Engineers Comments Regarding Surface Water Drainage

Application Reference:	WA/108/24/PL	Reviewer Reference:	ADC/PC
Planning Officer:	Amber Willard	Date of Review:	27/06/2025
Site Name:	Stoneybrook Farm Eastergate Lane Walberton BN18 0BA		
Application Description:	Erection of a re-purposed building for use as Class E (g) (iii) floor space, access, parking, drainage and landscaping. This application is in CIL Zone 3 (Zero Rated) as other development.		
Assessment Number:	1 of 1

Application Reference: WA/108/24/PL Site Name: Stoneybrook Farm Eastergate Lane Walberton BN18 0BA		Initial Issue Date: 27/03/2025 Issue Date: 27/06/2025 Reviewer Reference: ADC/SB & PC			
Summary and Recommendation:					
Objection					
Objection comments in bold , remaining comments to be addressed via condition.					
<i>Please note: Any DOC application should only have a maximum of two consultation responses. If this is the second response for an open application and there are still comments outstanding, then please object to the application.</i>					
	ADC Drainage Comments	Designer Response	ADC Drainage Comments		
Date:	27/03/2025	31/03/25	27/06/2025		
Condition Number: WA/108/24/PL

Scheme as approved under ref.s
APPC3810/W23/3316638
WA8722/PL

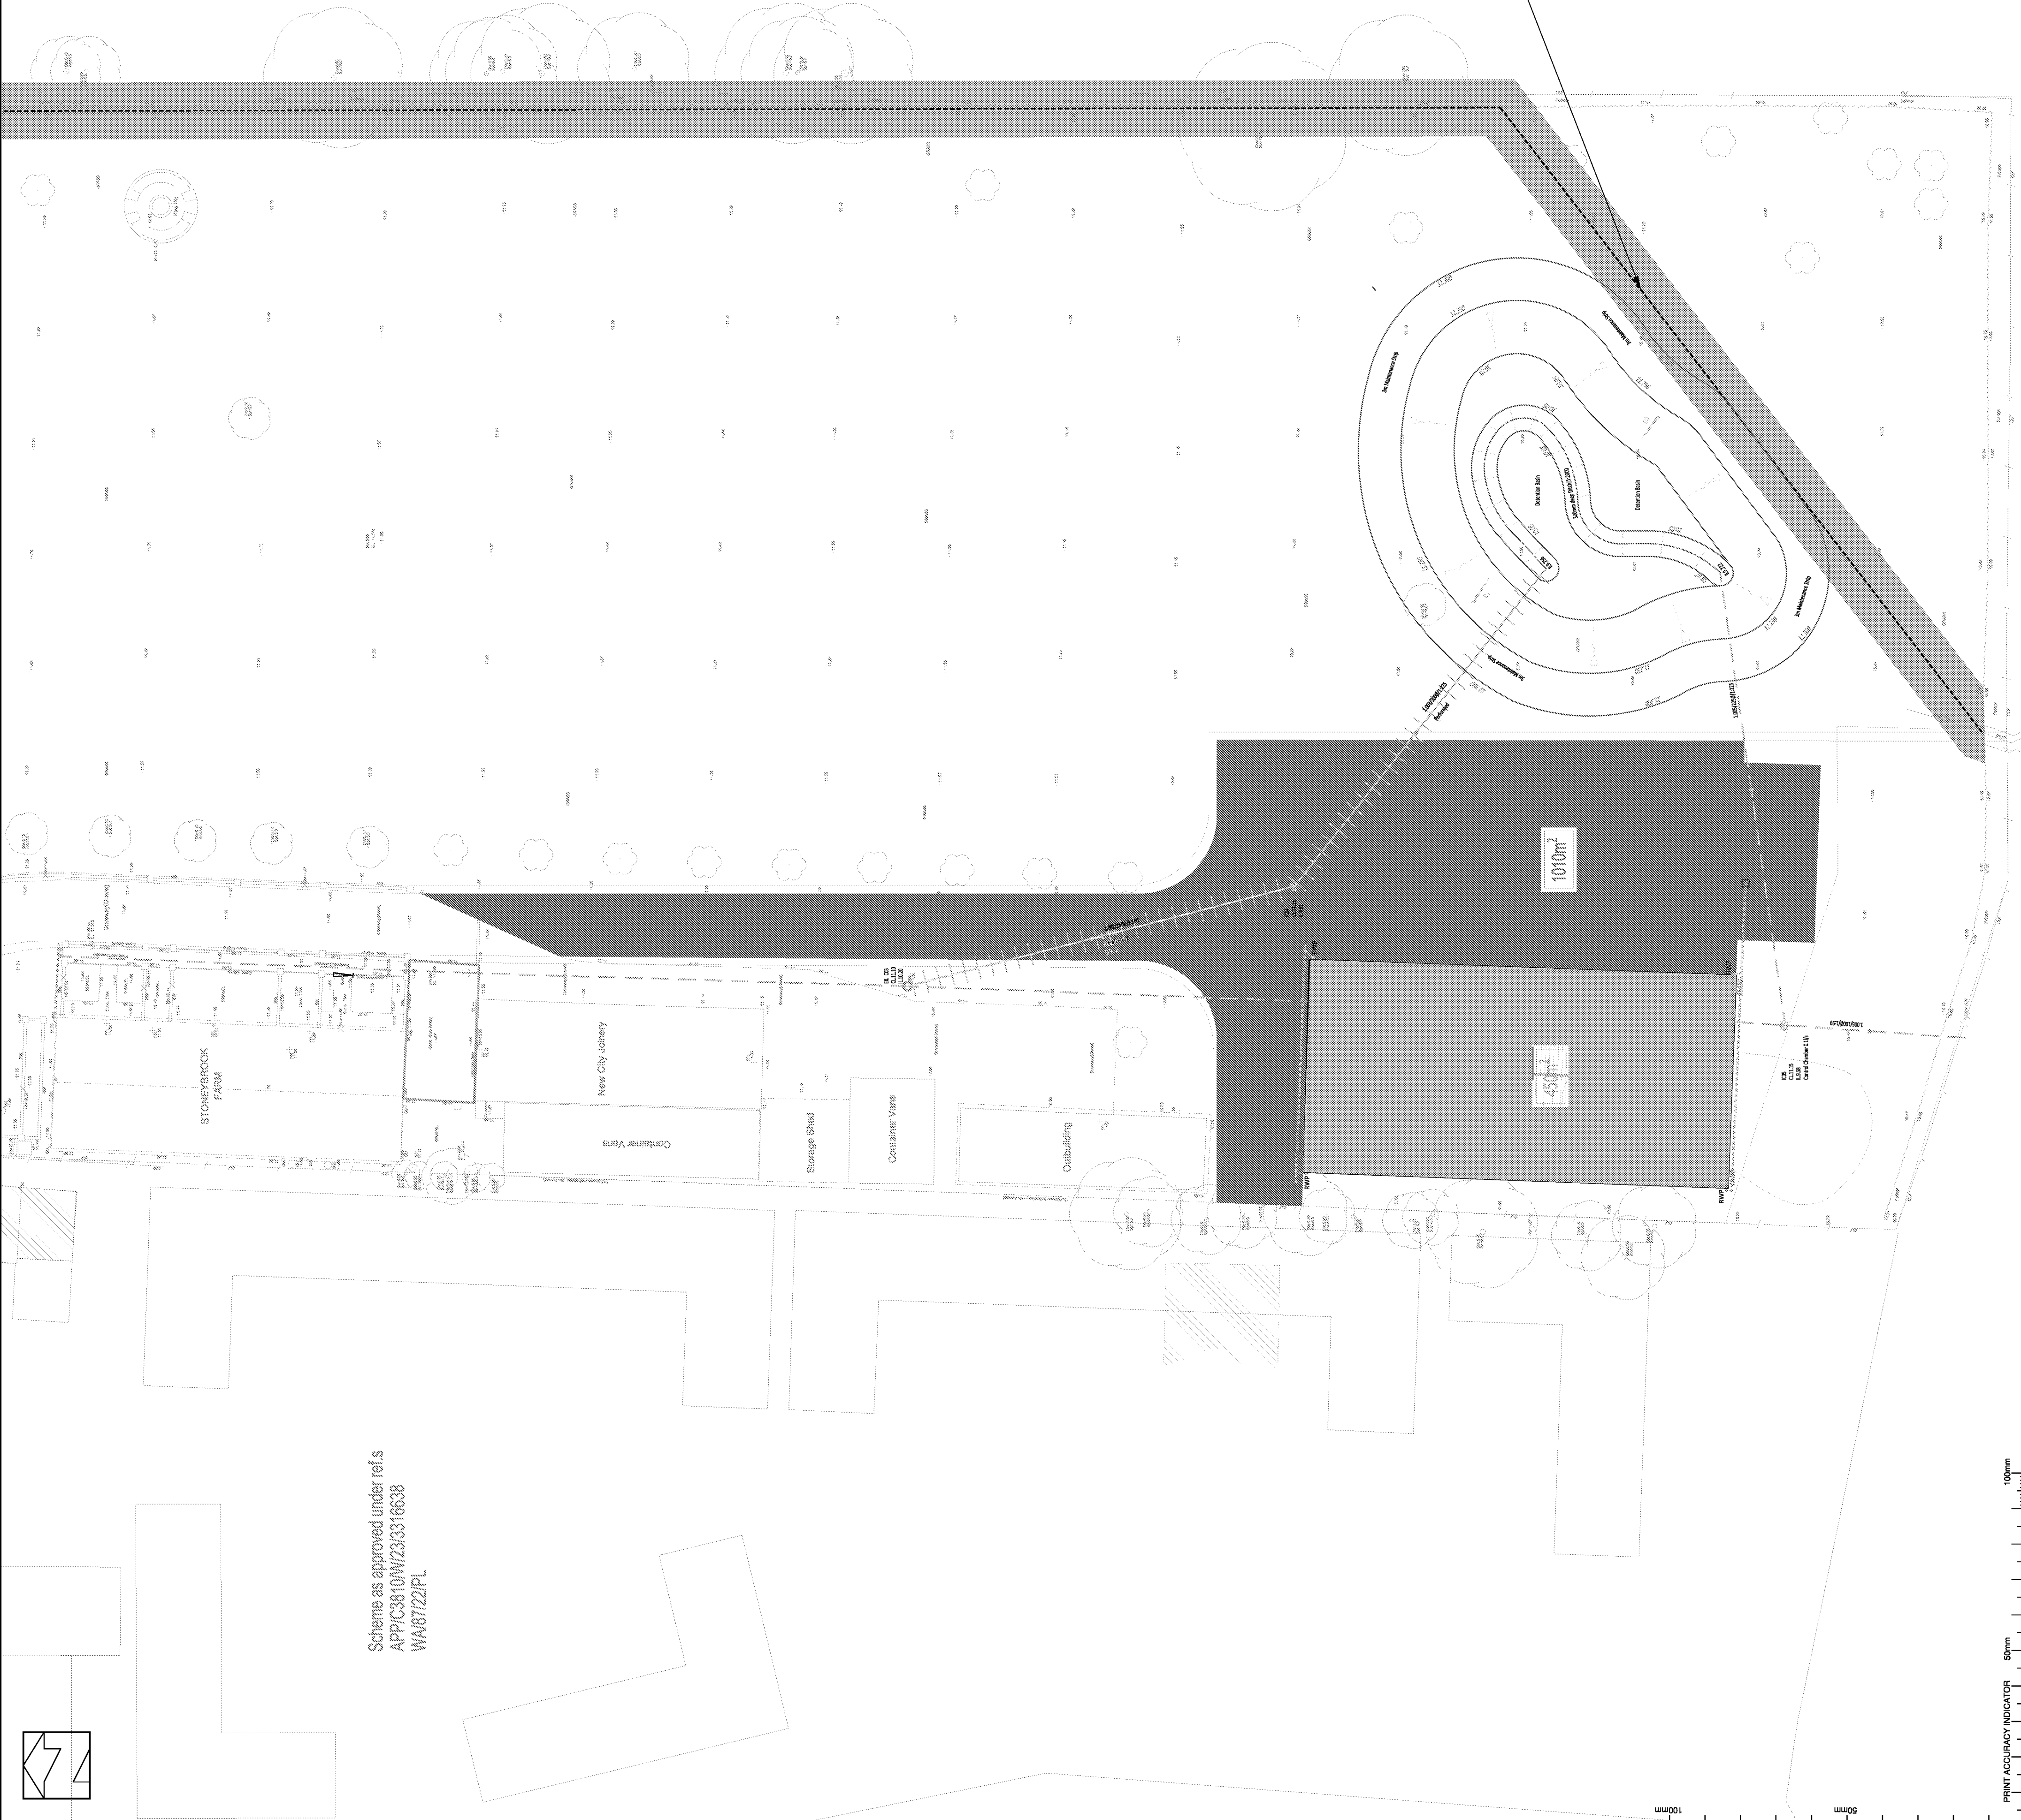
Comment Number					
1.	Please clarify the true bed level, top of bank level and existing connection level to the watercourse.	The bank level is 10.49m The inlet invert level set 1.102m below bank level = 9.388m Watercourse level set 9.350m	This does not achieve the best practice minimum 150mm freeboard required between ditch bed and pipe invert (38mm being achieved). This requirement is stated in our previous consultation response. The layout plan should be updated to clearly show the ditch bed levels/top of bank levels along the entire southern boundary. The existing levels along the length of the watercourse will potentially provide an insight into the true longitudinal profile and may present opportunities to lower the bed levels without compromising gradients and thereby help achieve greater freeboard. Also, it is noted that the existing 100mm diameter pipe outfall which you intend to utilise, passes through the RPZ (root protection zone) of an existing oak tree. This is a potential future/existing issue in terms of root damage to the pipework, thus increase to flood risk. In fact the pipe may already have issues in this respect. It is therefore strongly suggested that a new pipe is installed avoiding any RPZ's. This will help avoid it being questioned during the discharge of any planning conditions.

2.	Please clarify the proposed connection level and demonstrate that a gravity connection can be achieved. This will include pipe gradients and invert levels at nodes.	Existing connection to be retained, proposed to connect into existing chamber by gravity. Hydraulic network calcs attached	See item 1 above. The calculations have not been reviewed as they currently do not take account of criteria as set out in previous comments (ie. items 13,14,15). It is likely that storage will need to be increased once this is taken account of, however, as there is scope within the site to do this, it can be dealt with during the discharge of any planning

conditions. The applicant should also be aware that the landscaping scheme currently conflicts with the drainage scheme in part (ie. proximity of trees to pipework/pond), and will therefore need to be adjusted before either scheme is approved.

3.	Clarify any land raising that is proposed on the site and demonstrate that this will not increase flood risk.	The Exceedance Plan is attached, Surface Water routes to the existing low spots on the southern boundary.	Please clearly indicate all areas of the site where the ground is to be raised and the level to which it is being raised. This information should be included on the exceedance plan, ensuring that the flow arrows are adjusted if necessary.

4.	Clearly show the location and easement for the watercourse on plans.	The watercourse easement is shown.	The easement shown exceeds the required minimum 3m distance from the top of the bank of the watercourse and is therefore deemed acceptable. For clarity, clearly show the watercourse on the layout plan, together with the measured distance from the top of bank to any structure.
